Re: Exhibition of Environmental Impact Statement for the Sydney International Convention, Exhibition and Entertainment Centre Precinct, (SICEEP), Darling Harbour, Sydney – International Convention Centre Hotel (SSD 6116)

The Heritage Division, on behalf of the Heritage Council of NSW, notes that the Project is a State Significant Development (SSD) Application for demolition of existing site improvements and construction of a 38 storey building for hotel use and associated restaurant, ballroom and guest and visitor facilities and public domain works.

View of tower from Pymont Bridge

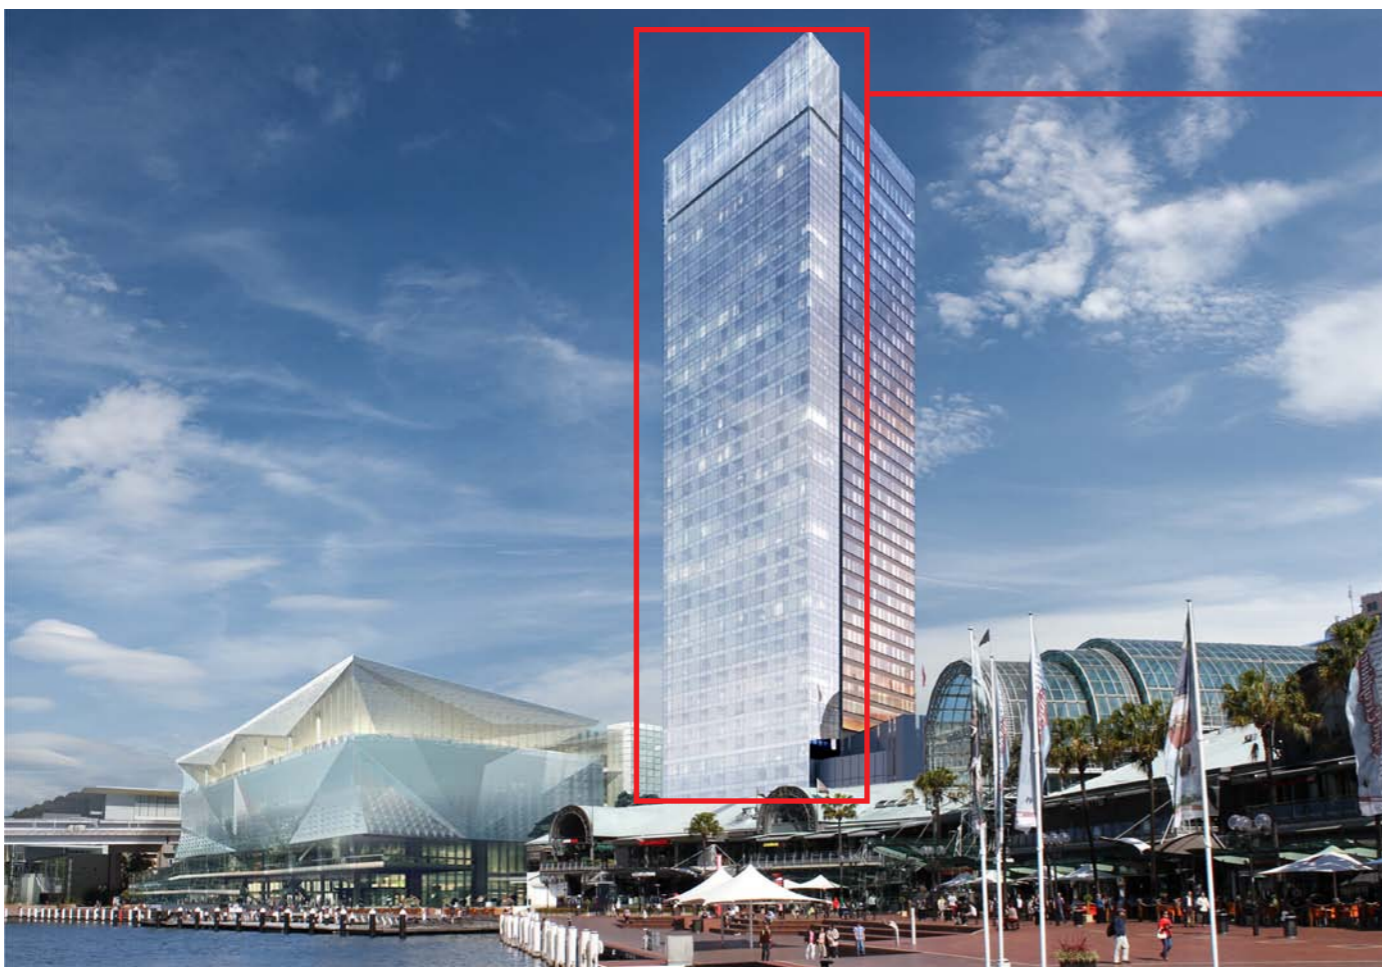
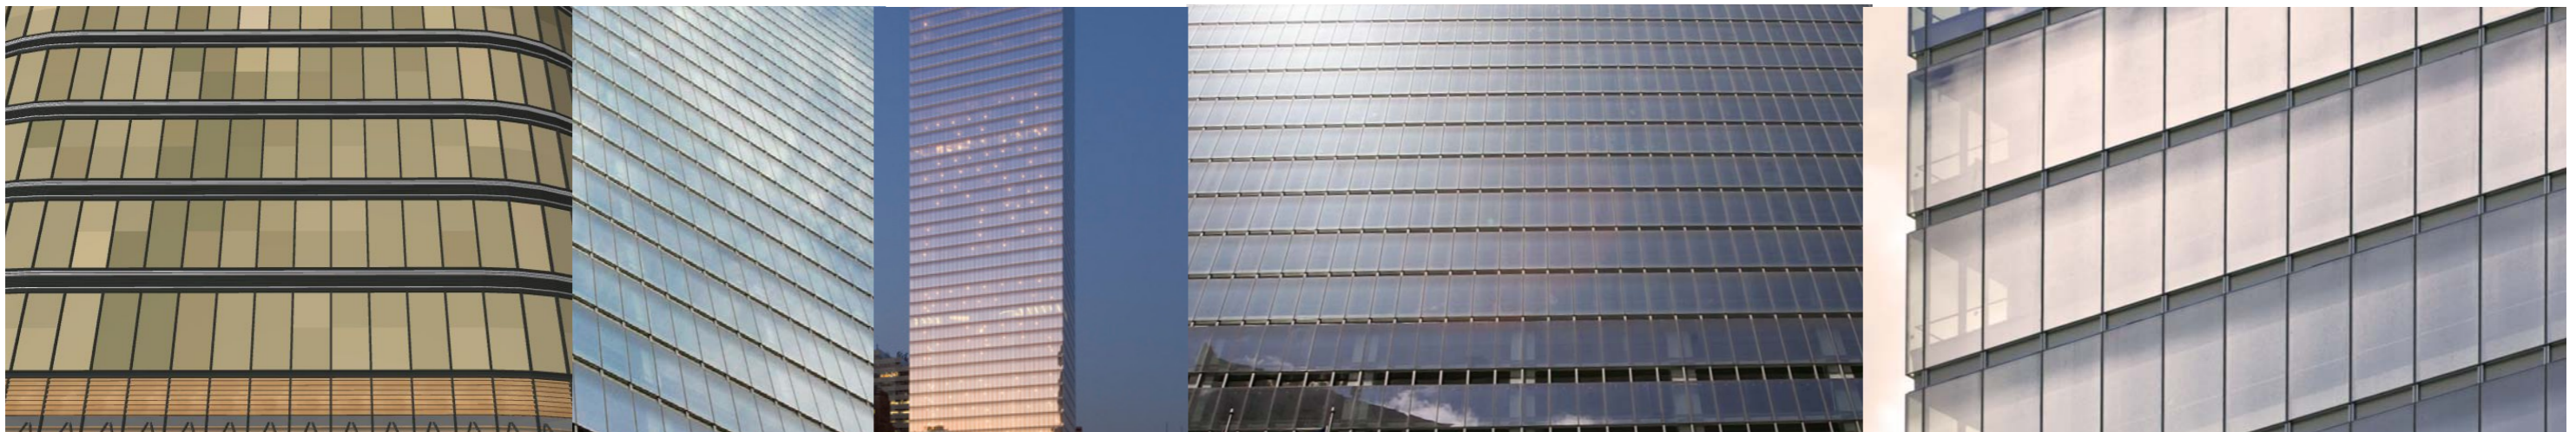
The Heritage Division notes that the rectilinear form and scale of the proposed hotel tower comprising of 31 storeys is likely to have some adverse impact on the setting of the Pyrmont Bridge and some key views of the item. The proposed tower could also have some adverse impact on the setting of other local items in the vicinity. Consideration should, therefore, be given to design modifications that mitigate these impacts, including reduction in the height of the tower as well as reduction in its volume and resultant bulk on the upper levels, and further exploration and resolution of the external architectural treatment such that the *perceived mass of the tower* is reduced.

1. The design of the proposed tower should be modified to mitigate impacts on the State Heritage listed Pyrmont Bridge and its setting. Modifications should include reduction in the height of the tower, and its volume and resultant bulk on the upper levels, and further exploration and resolution of its external architectural treatment such that the *perceived mass of the tower* is reduced.
